Richard Boyd Barrett T.D.,
People Before Profit,
Leinster House,
Kildare Street,
Dublin 2,

28 October 2022

Re *DART* West Planning Application

Ref: 314232

Date	Job No.	Status	Rev.	Sheet
April 2022	P/101086	F1-Approved & accepted	V01	2 of 3

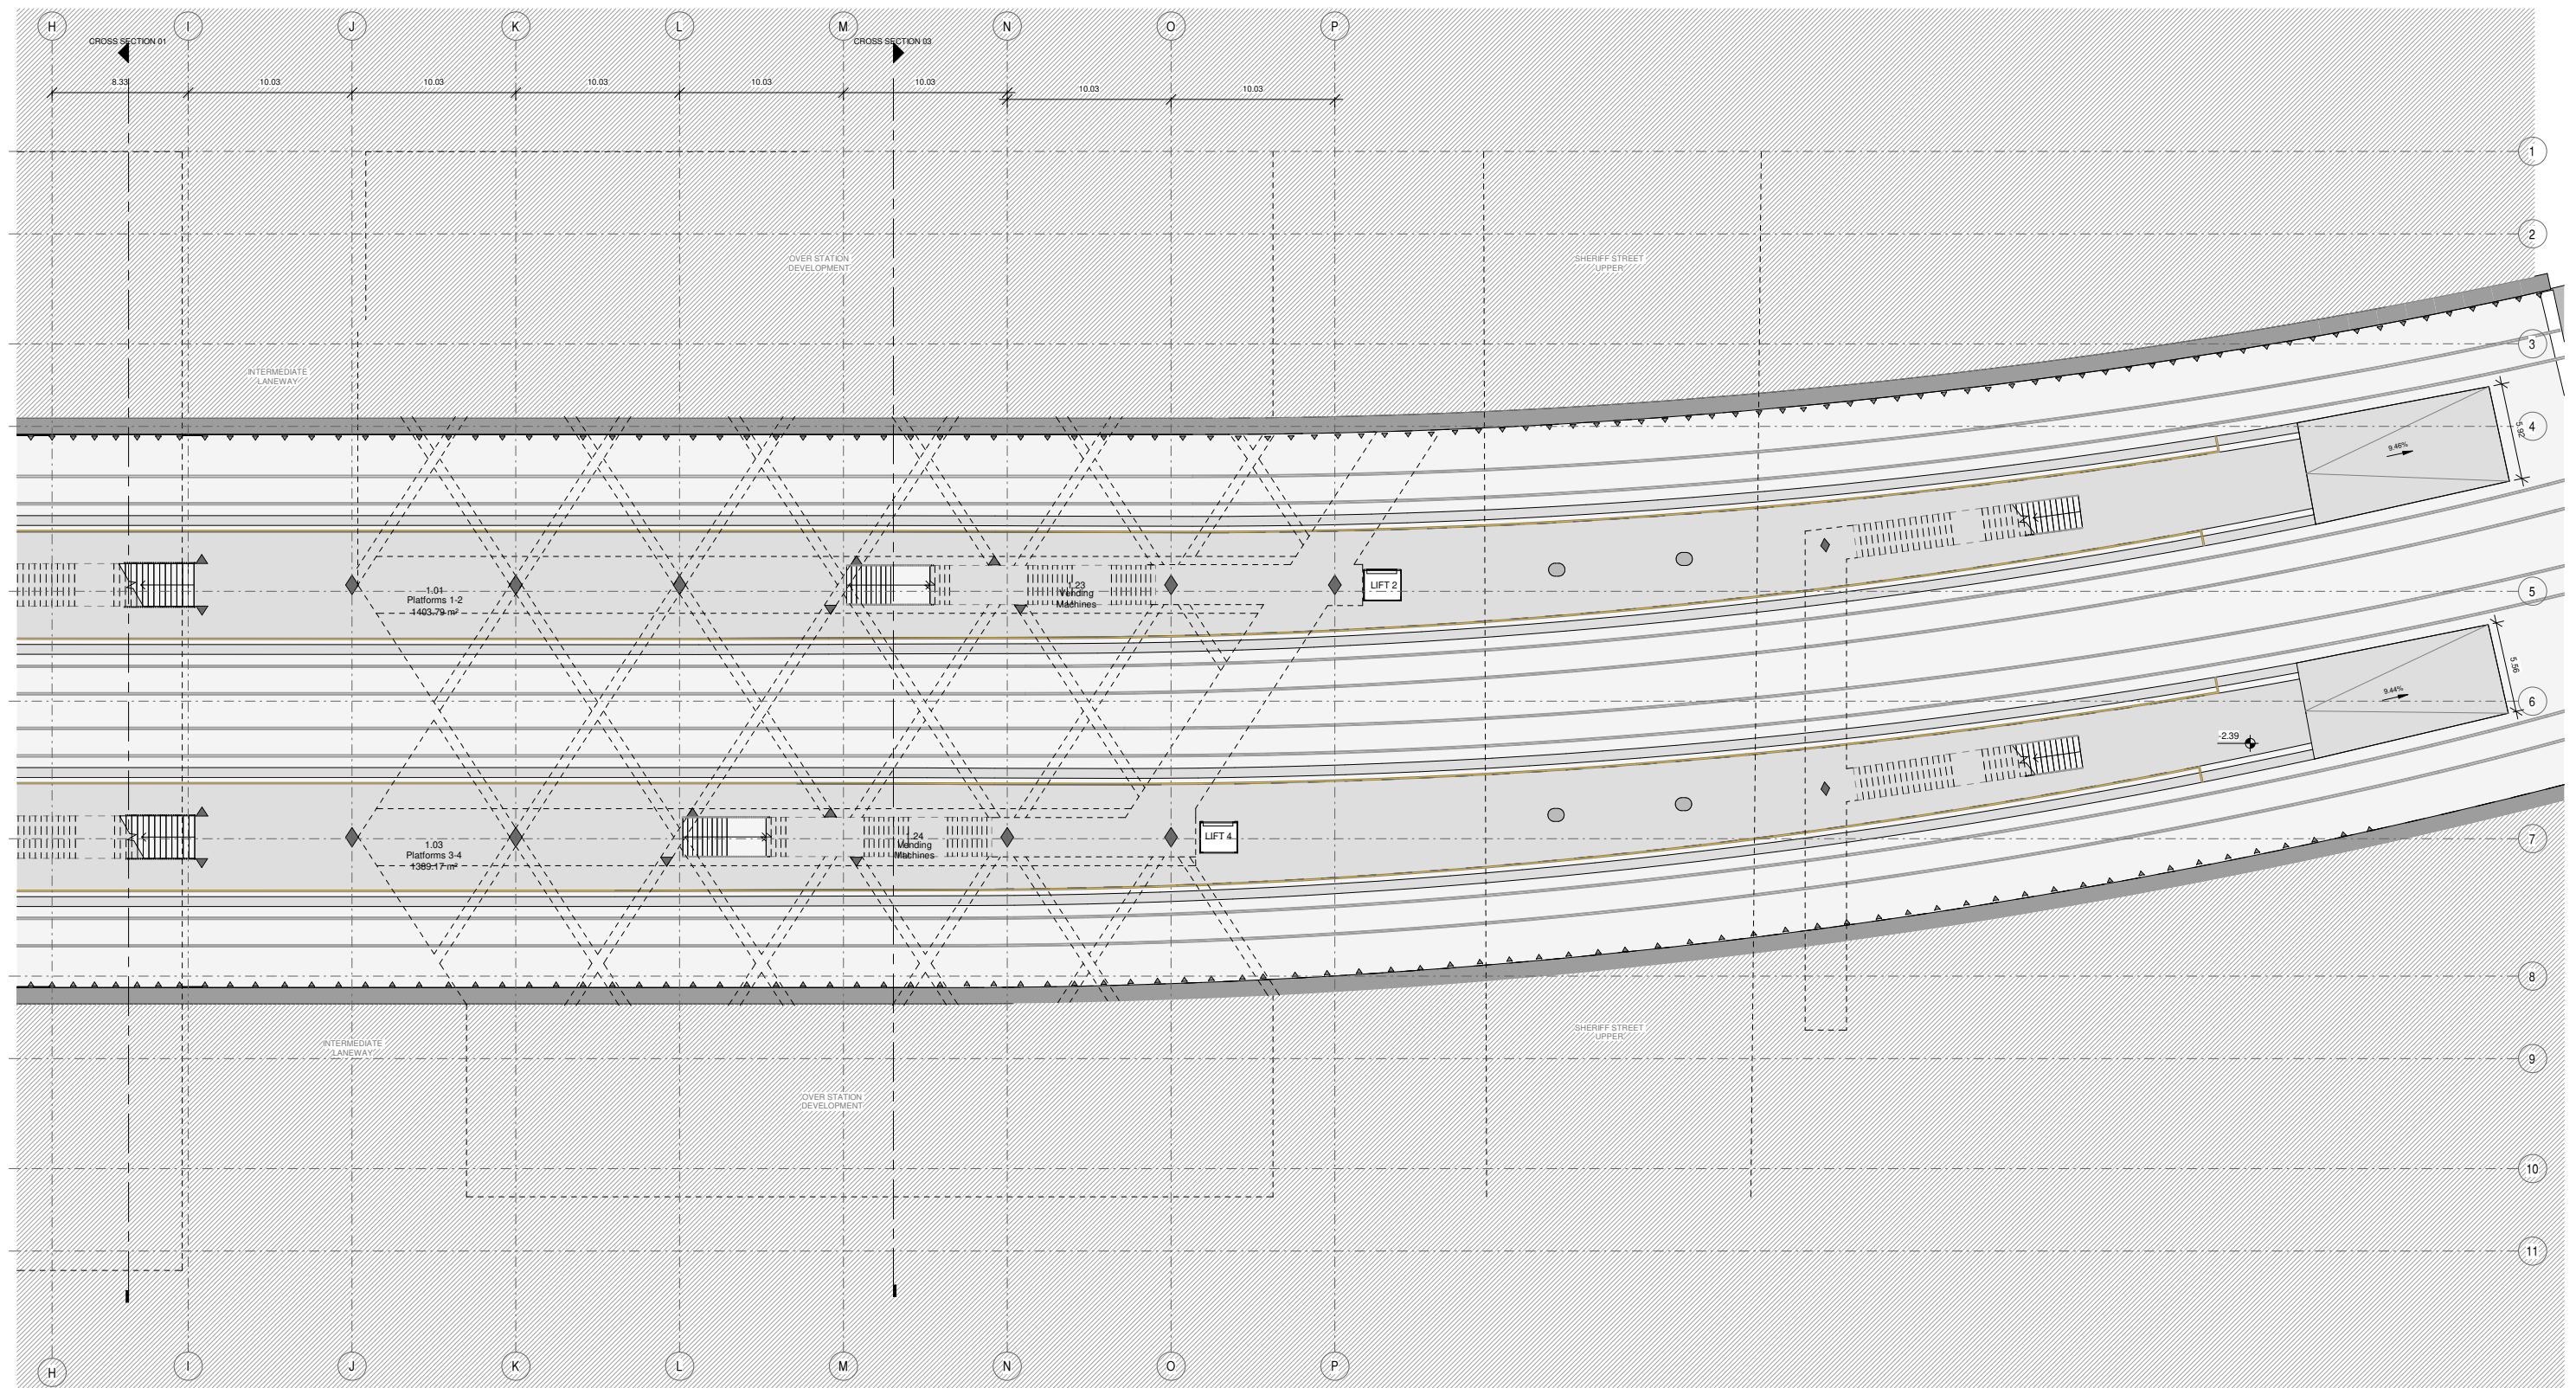
According to media reports €100 million may be needed for the plan by Irish Rail to develop a new underground station at Spencer Dock. This is an enormous cost, from which there seems to be very little immediate benefit. Ultimately the station may be useful if the *DART Underground* tunnel is built – yet that is not currently happening.

As this development would be underground it costs many times more than a station built overground – and is also exposed to a lot more risk in terms of the project encountering unforeseen difficulties that are then more expensive to resolve.

Hence this element of the scheme should be deferred – and that this capital instead be spent on stations that need to be opened, such as at Croke Park, Phibsborough etc.
